Please could the attached plan ref: ADS-005-P be added to [BR/302/18/PL](#)

From: Nick Hopper <[redacted]>
Sent: 10 October 2019 13:32
To: Richard Castro-Parker <[redacted]> Donn Cullioni <[redacted]>
Cc: Daniel Vick <[redacted]>
Subject: Re: 71 Hawthorn Road

I am writing to request the following re: 71 Hawthorn Road:

SITE PLAN (Proposed) @1:200

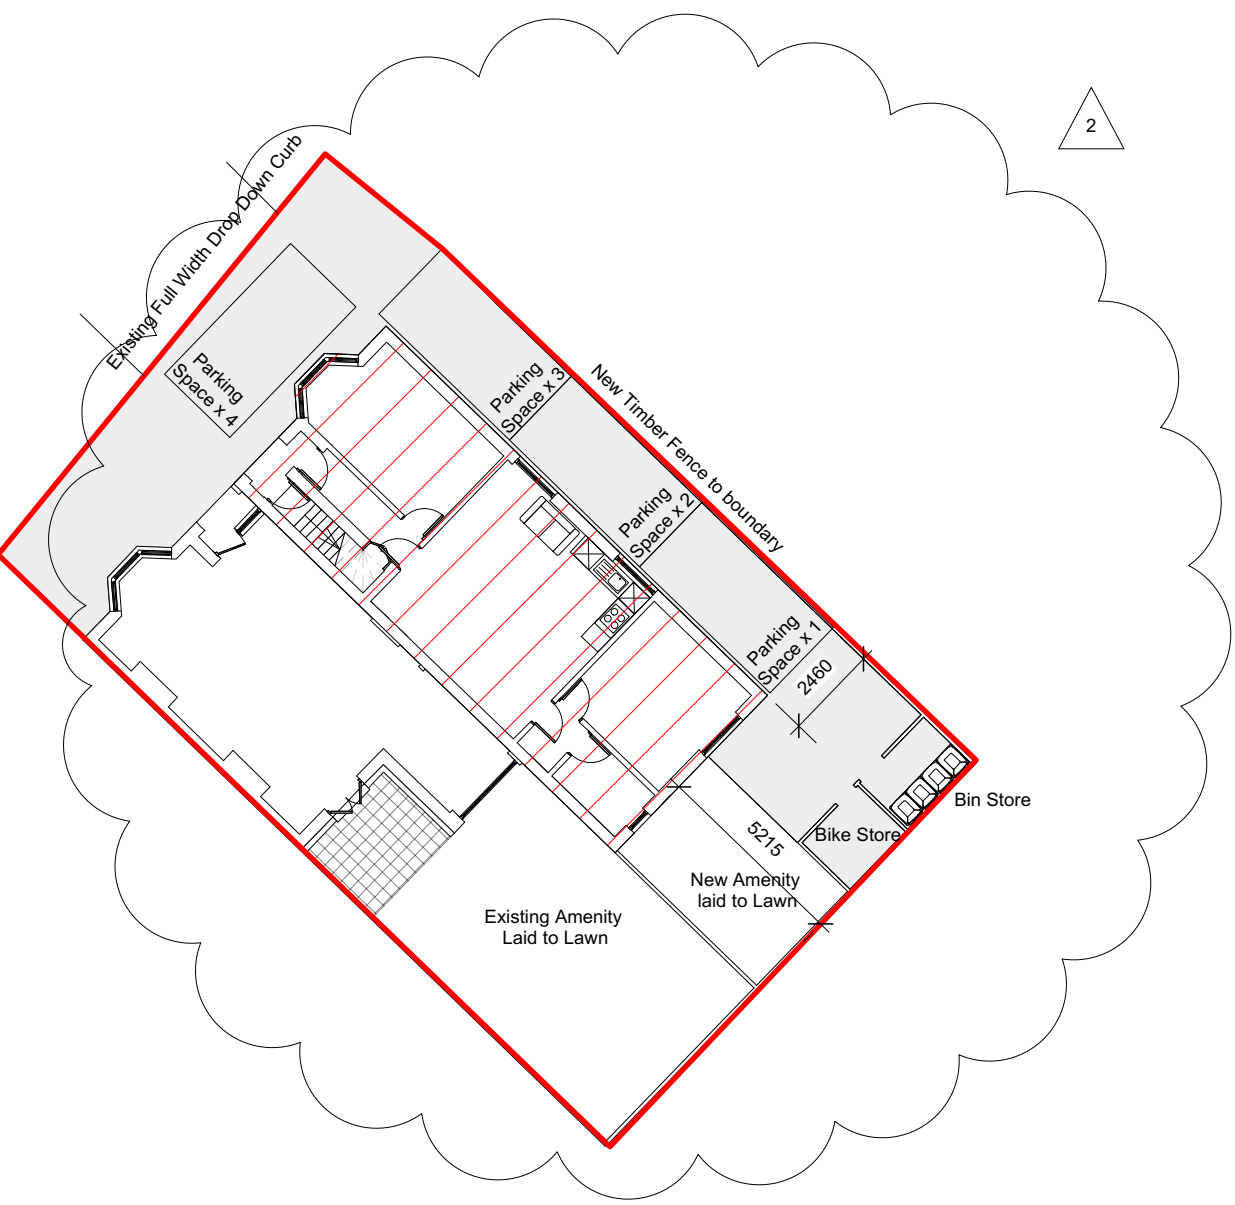
1. Amended plans showing the proposed single storey rear element as viewed from the west. The plans show the single storey extension as seen from the east but not the west.
2. I draw your attention to the highways comments where they state that as space number 4 is a parallel space it should be shown to be 2 x 6 metres to accommodate for the additional maneuvering room required.
